**Job Name:** M42 Junction 6 Improvement – Development Consent Order (TR010027)  
**Job No:** 45977  
**Note No:** 2  
**Date:** 16<sup>th</sup> September 2019  
**Prepared By:** N Fern  
**Subject:** Transport/Highways Representations on behalf of the Gooch Estate

- 1.2. This second Technical Note responds to Highways England’s comments from July 2019 (Document: 8.33 *The Applicant’s comments to written representations which were received at Deadline 1*), prepared in response to the previous written representations made by PBA on behalf of the Gooch Estate in Technical Note 1 (May 2019).

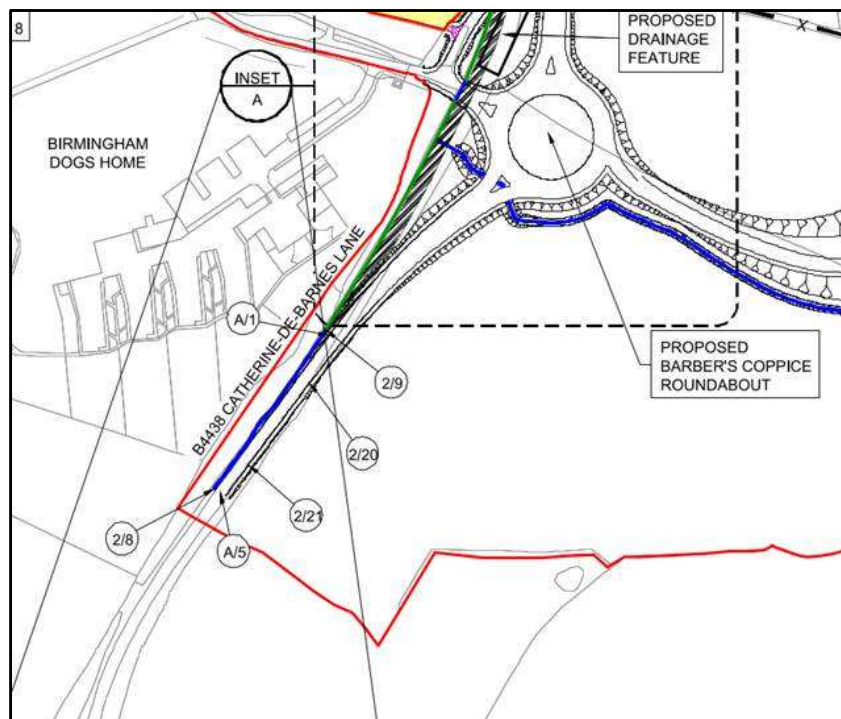
- 4.3. PBA would like to understand the rationale for moving the access so far south, and not reinstated in a similar location. This is because moving the field access south restricts visibility to the access due to the bend on Catherine-De-Barnes Lane and the woodland. This is not ideal for slow moving agricultural vehicles entering / exiting the access, particularly for vehicles travelling northbound. For a 50mph speed limit, this results in a sub-standard visibility splay requiring a visibility splay of 160m.

- 4.7. The Applicant's response is acknowledged, although does not provide any further update from the June 4<sup>th</sup> meeting. PBA request a revised General Arrangement drawing is prepared showing the exact access location to demonstrate commitment to the relocation. PBA also seek sight of the visibility review undertaken to confirm that this revised access location is suitable.

*Following a review of the concerns raised in the technical note in respect to visibility at Barber's Coppice, the Applicant proposes, subject to discussions with the local highway authority and the Gooch Estate, to shift the field gate access north of Point 2/21 presented in the Streets, Rights of Way and Access Plans submitted as part of the dDCO [APP-009/Volume 2.5].*

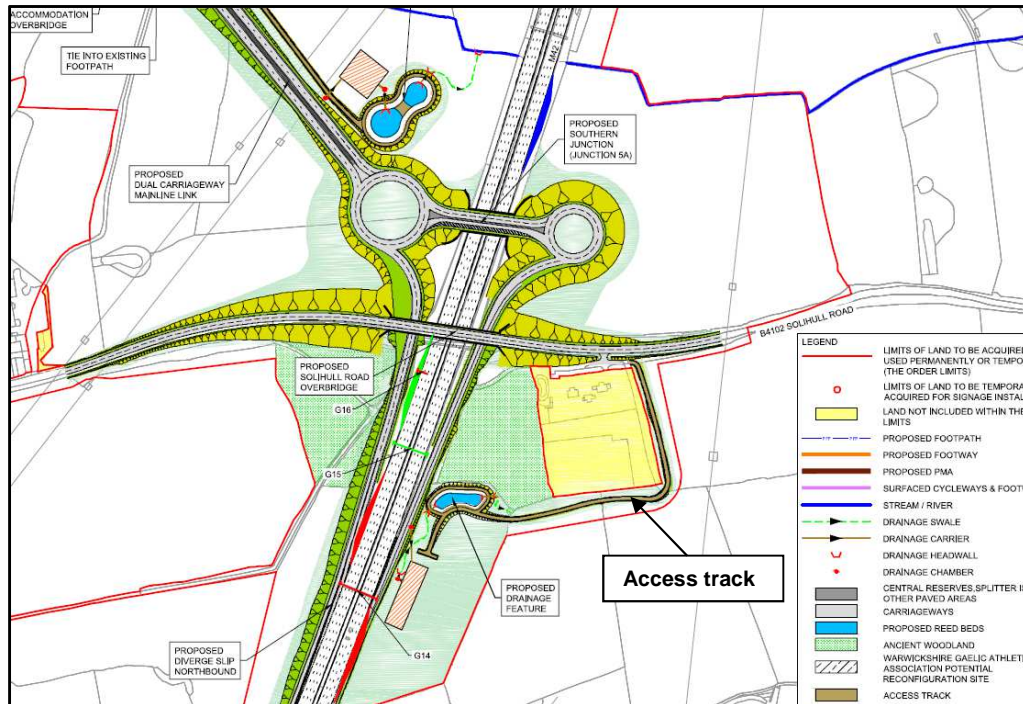
- 5.3. PBA would still query whether the Gooch Estate can have rights of access to this new access track. The Applicant states it will be an unsurfaced track that is 3.5m wide with a 0.5m verge on both sides. This width should be sufficient for tractors (generally 2.5m wide), but not for combine harvesters (which are generally 4m wide). Therefore, combines will have to use an alternative access unless the Applicant can provide a 4m wide access track.

- 5.5. The Applicant’s response is noted, although provides no reference to the update provided at the June 4<sup>th</sup> meeting. PBA request an update on the comments made at the meeting, with the end intention to provide a revised/updated General Arrangement plan showing a potential new access from Solihull Road to the access track.

*The Applicant has proposed the construction of an access track on land plot 2/3e for the inspection and maintenance of the surface water attenuation and treatment devices. If the Gooch Estate wants a right of access over this proposed access track, the Applicant is open to discussions to determine the practicalities of these modifications.*

Figure 2 – Tractor swept path

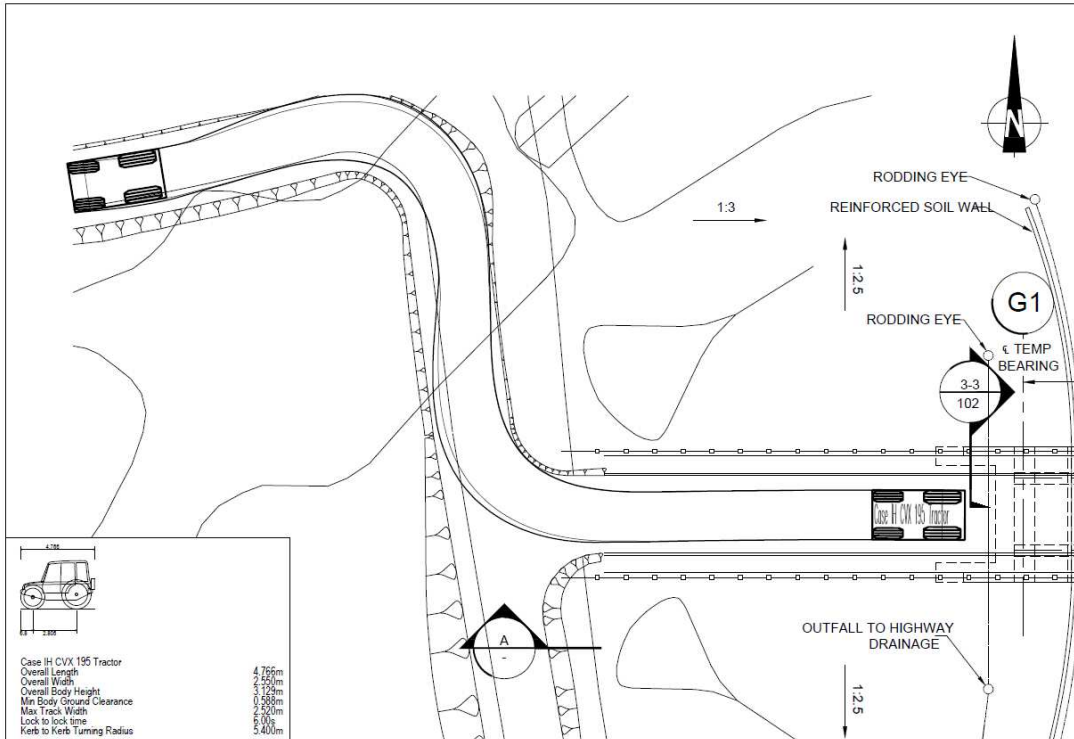
- 6.5. In terms of the bridge width, the tractor is shown to cross within the bridge carriageway (at 2.5m wide). The combine harvester width is 4.060m meaning it would need to use one of the verges to cross (which is not ideal).
- 6.6. PBA have also attempted to track the vehicles around the two 90 degree bends the Applicant are proposing on the southern side of the accommodation bridge. The swept path drawings above demonstrate this is not achievable. Therefore, PBA would request that, as part of the detailed design, two separate new gated accesses are provided directly opposite the bridge on the southern and northern sides to the Gooch Estate land to allow the safe passage of agricultural vehicles. PBA note that the southern side may potentially have an issue with gradients between the track and the field. This will need to be considered in this provision.

- 6.8. The Applicant's response is acknowledged and welcomed, and provides more detail than the meeting held on June 4<sup>th</sup>. PBA request confirmation of this intention, with a revised General Arrangement drawing so it is committed through the DCO process, since there is a level difference that needs to be considered in such a provision.

*As recommended in the Peter Brett Associates technical note, it is the intention of the Applicant to provide access points directly approaching the accommodation overbridge to enable vehicles to traverse between the respective fields to the north and south of the new mainline link road.*

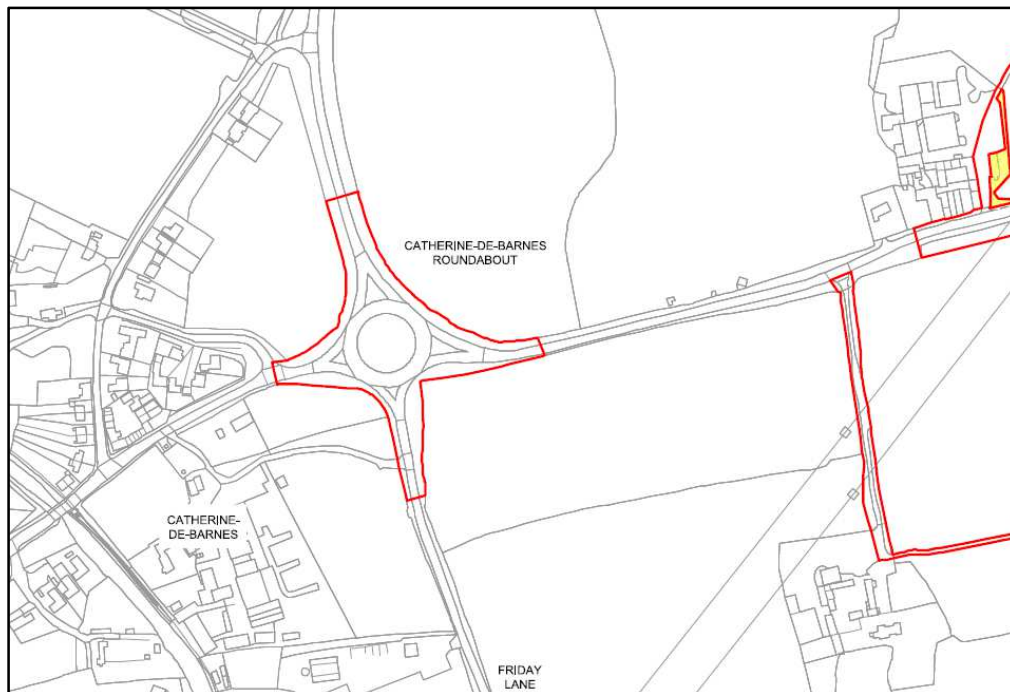
- 7.1. On the General Arrangement plan (Sheet 2 of 7) the existing roundabout is shown to be within the Order Limits, with a section of the Gooch Estate's land taken on the eastern side of Friday Lane and on the southern side of Solihull Road. Clarification is required as to why this roundabout (and land) is required within the Order Limits since no reference can be found in the application material to mitigation/enhancement works at this roundabout. Furthermore, PBA requests sight of the ARCADY junction capacity assessment model results for this existing roundabout.
- 7.2. An extract of Sheet 2 of 7 is reproduced below.

*The land surrounding and including Catherine-de-Barnes Roundabout has been included to enable the Applicant to undertake any signage or road marking modifications necessary to reflect the wider scheme proposals.*

Furthermore, the traffic forecast comparisons, which compared a do-nothing scenario, no scheme, to a do-something scenario, implementing the Scheme, identified that the Scheme would not add any traffic to this junction. Henceforth no capacity or ARCADY assessments have been undertaken.

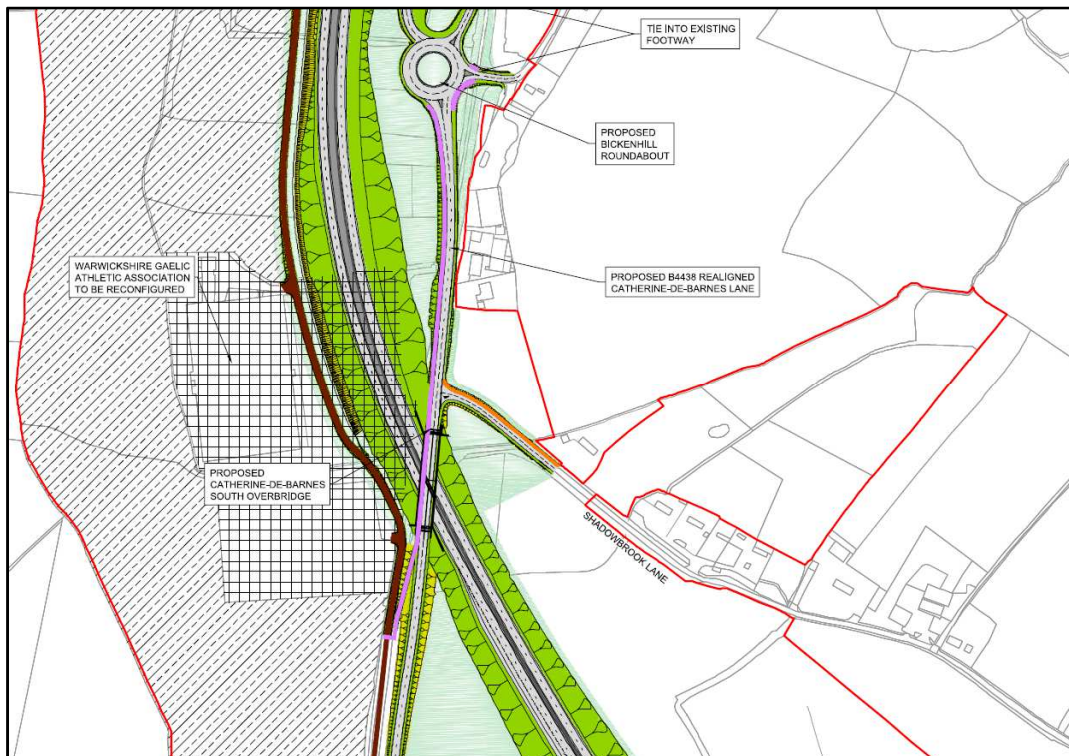
8.1. The parcel of land to the north-east of the proposed junction is shown to be within the Order Limits but does not appear to be utilised in the Scheme. PBA would request that any remnants of the parcel of land not used is transferred to the Gooch Estate to provide the potential to enhance the junction in the future should our client's severed northern land parcel be developed for strategic development. PBA also request sight of the PICADY junction capacity assessment model results that support the proposed Catherine-De-Barnes Lane / Shadowbrook Lane realigned priority T junction.

- 8.6. PBA welcome the provision of the PICADY results.
- 8.7. PBA request an update from Highways England on the Shadowbrook Lane priority junction relocation, as per the comments made in the June 4<sup>th</sup> meeting (and sight of a revised General Arrangement drawing).
- 8.8. The response regarding the future of the area of land north of Shadowbrook Lane is inconsistent with the comments/advice given in the June 4<sup>th</sup> meeting. PBA request clarity regarding this land and future intentions.

*In respect to the request for the PICADY junction capacity assessment, the Applicant has provided the results of this assessment below. These results indicate that the junction will operate well within its operational capacity with the 2041 traffic demand forecasts.*

*In accordance with current practice, any part of plot 3/32a which is not permanently acquired by the Applicant shall be returned to the current owner.*
